Planning Inspectorate (the Drovers Solar
Farm)

Reference: OR-0009338/01
Customer reference: EN0110013

**Deadline 3 submissions response letter
The Drovers Solar Farm**

This letter constitutes the Environment Agency's Deadline 4 response regarding the Deadline 3 submissions. It is structured as follows:

DRAWING TITLE:
Figure 12.14: Work No. 3 Maximum Potential Foundations and Groundwater Elevations

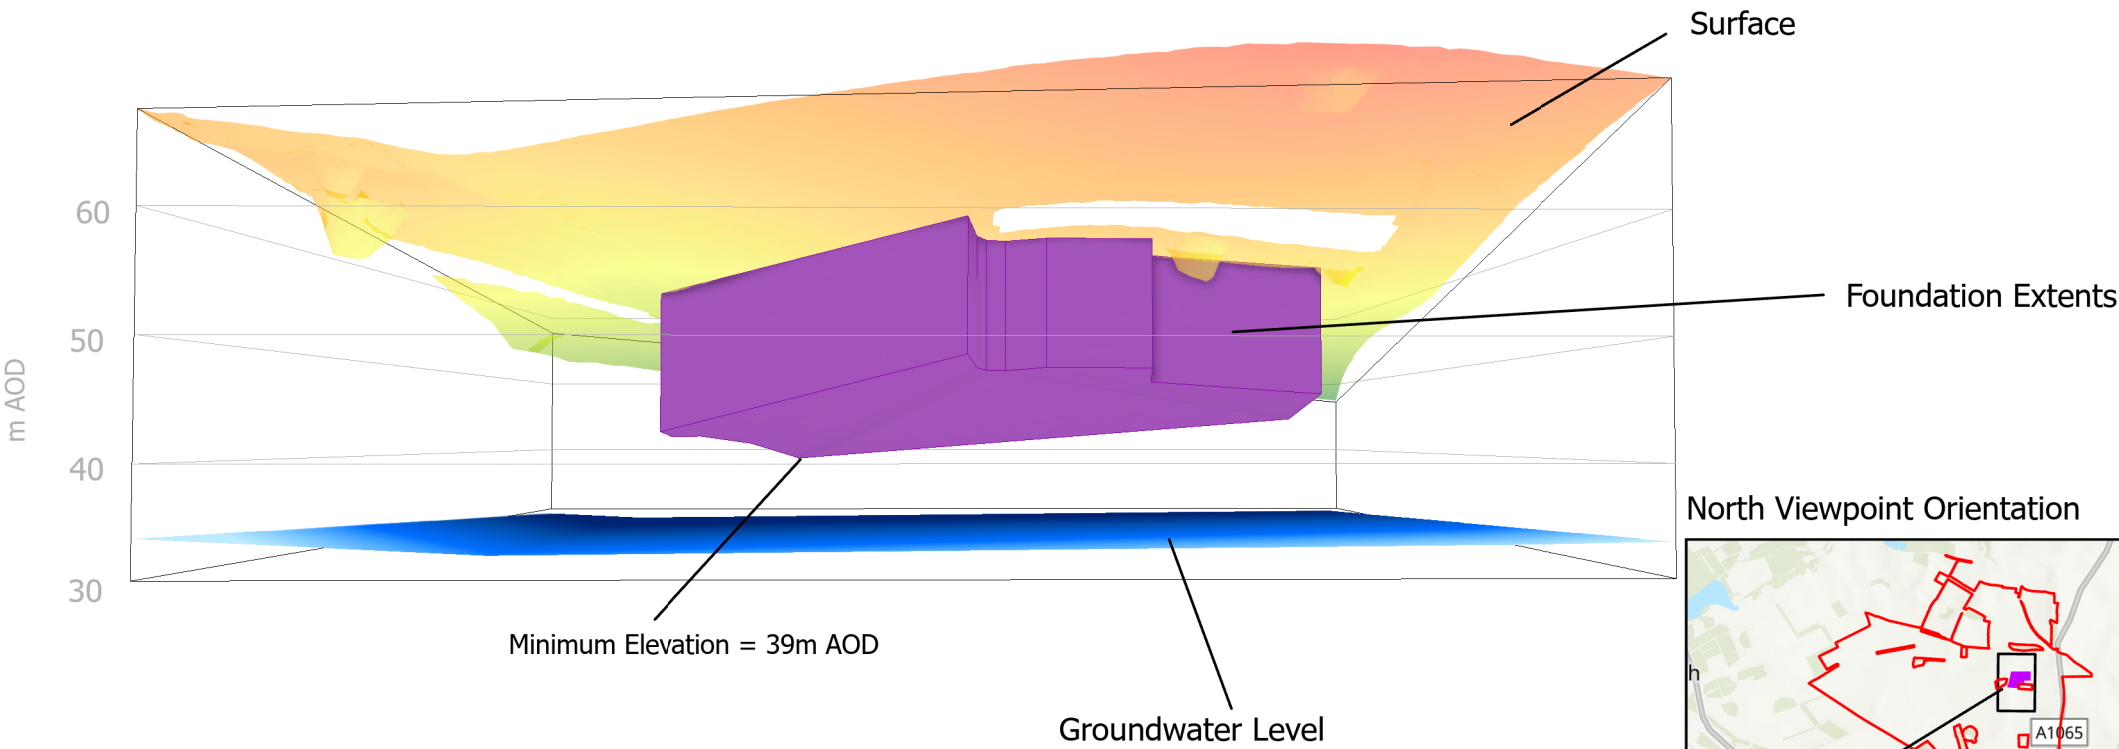
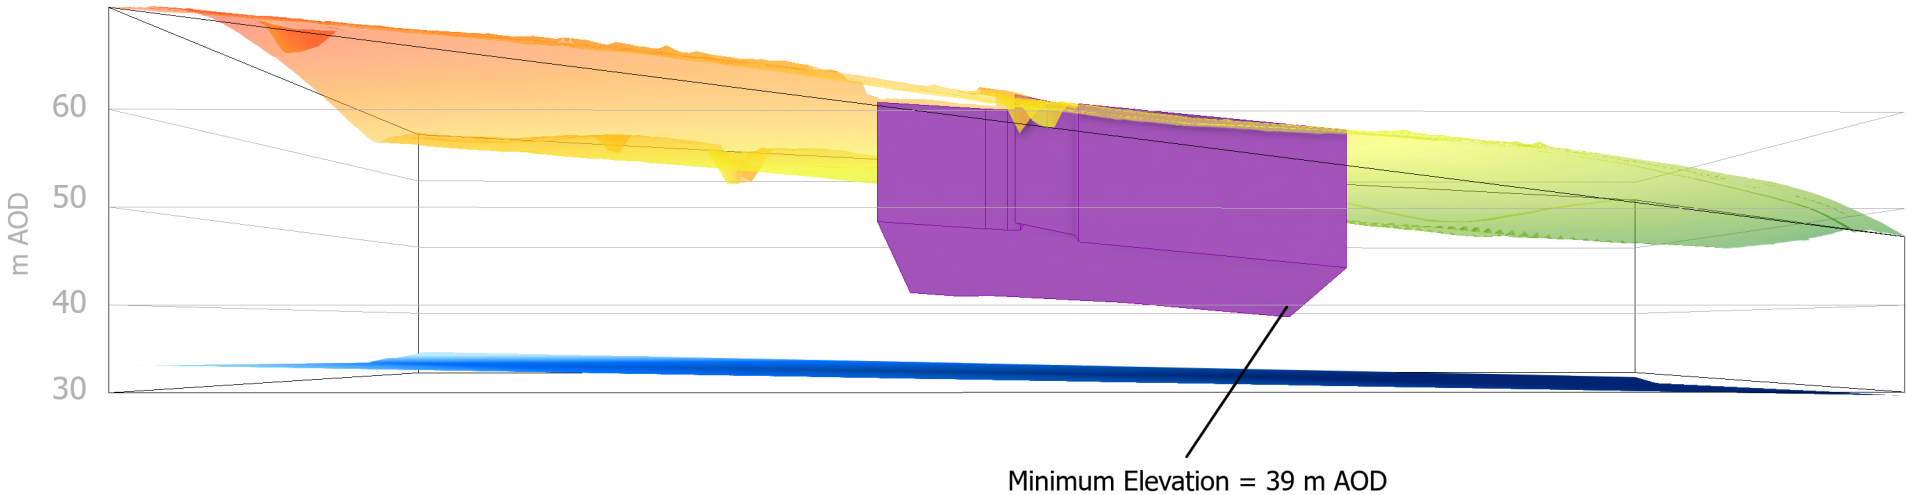
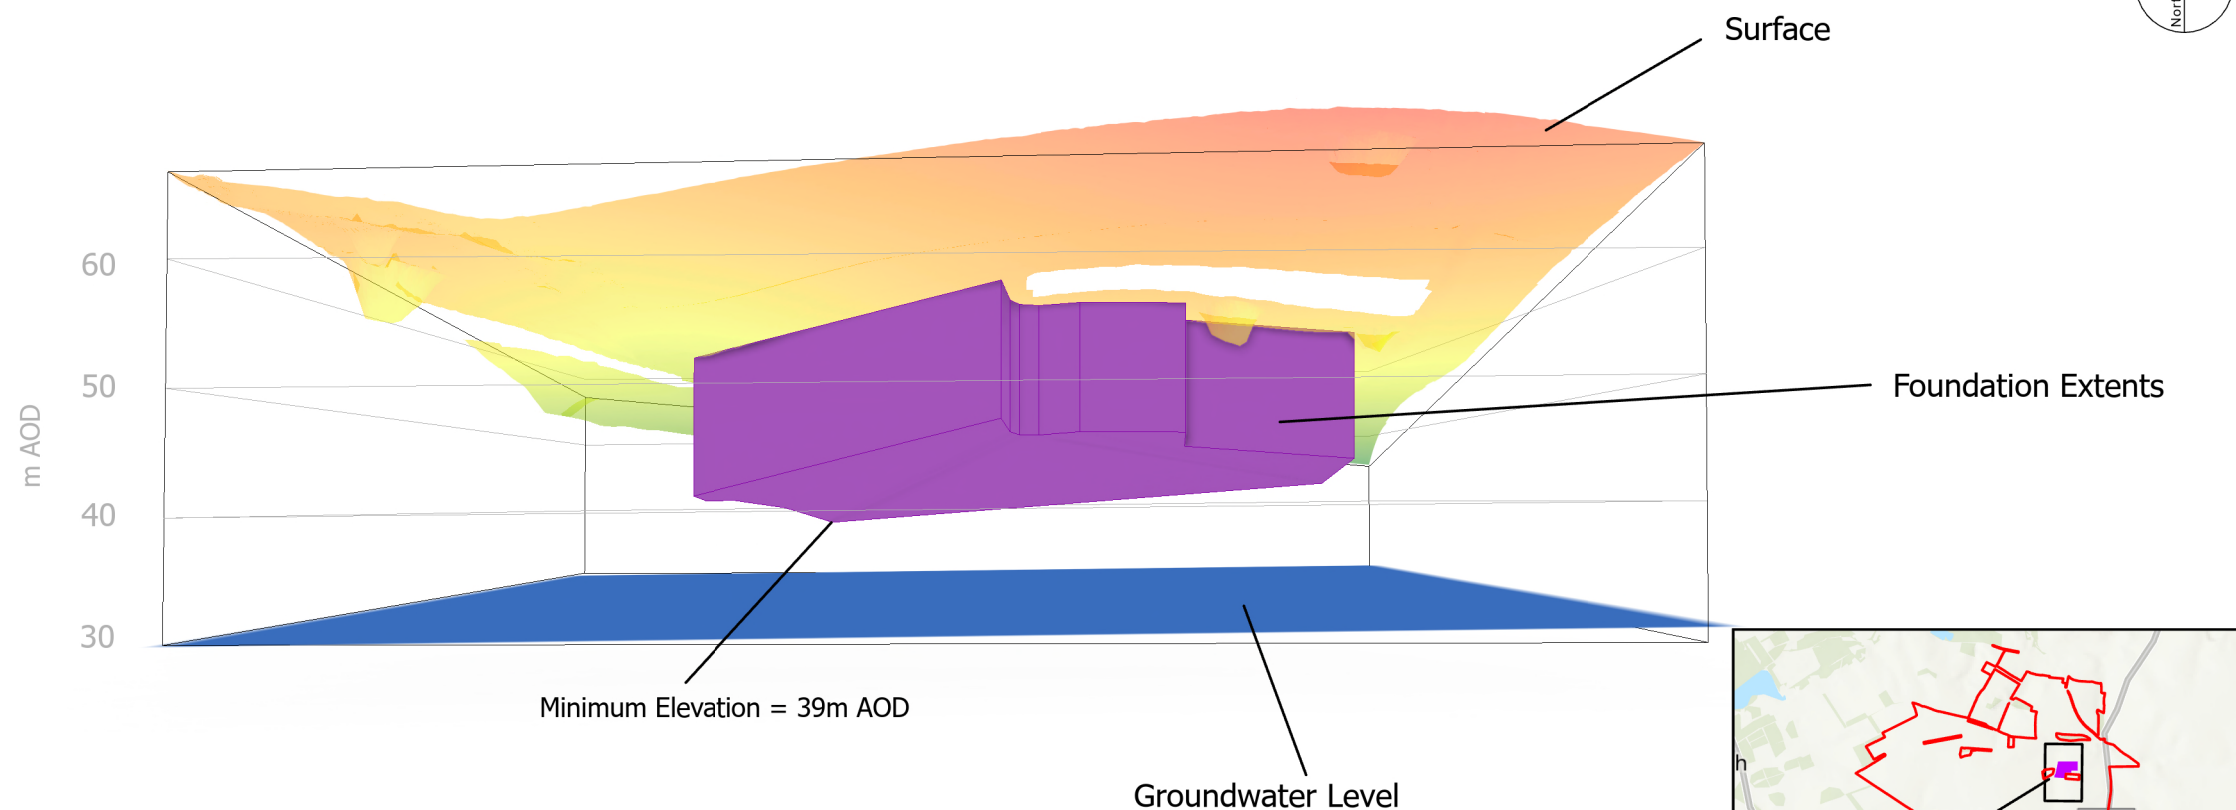
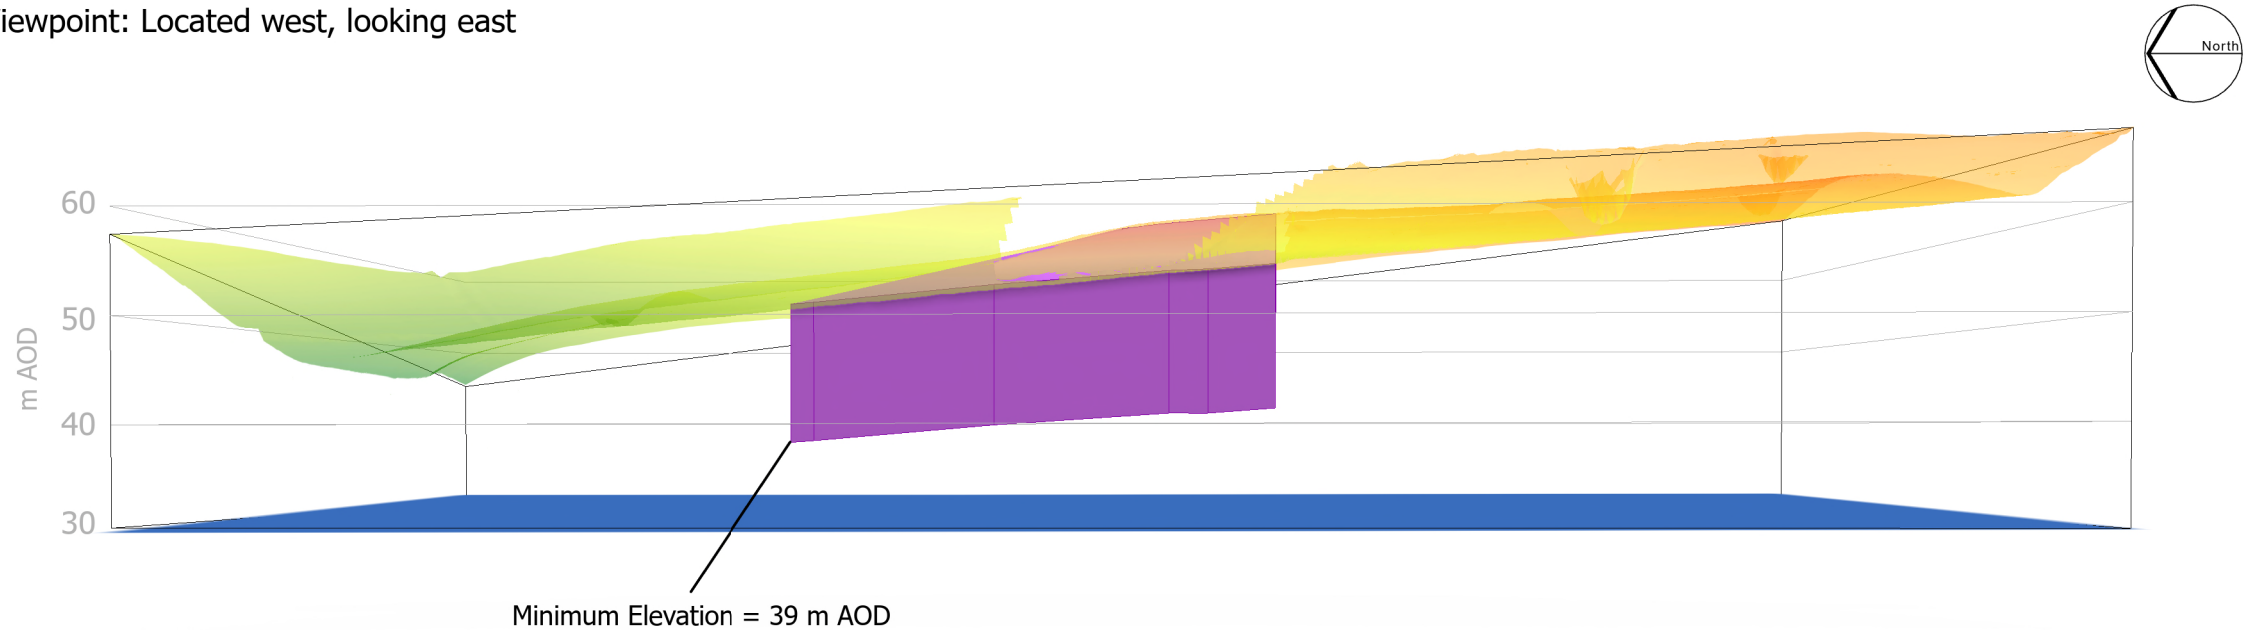
We were concerned that figures 12.13 [[APP-127](#)], 12.14 [[APP-128](#)], 12.15 [[APP-129](#)] and 12.16 [[APP-130](#)] do not clearly define the area represented by the drawings, including view orientation, or the elevation values.

- 6.3.1 ES Figure 12.13 Work No. 2 Maximum Potential Foundations and Groundwater Elevation [[REP3-043](#)]
- 6.3.1 ES Figure 12.14 Work No. 3 Maximum Potential Foundations and Groundwater Elevation [[REP3-044](#)]

We find the updated figures satisfactory for defining the 3D model view, and elevation the maximum extent of the foundations.
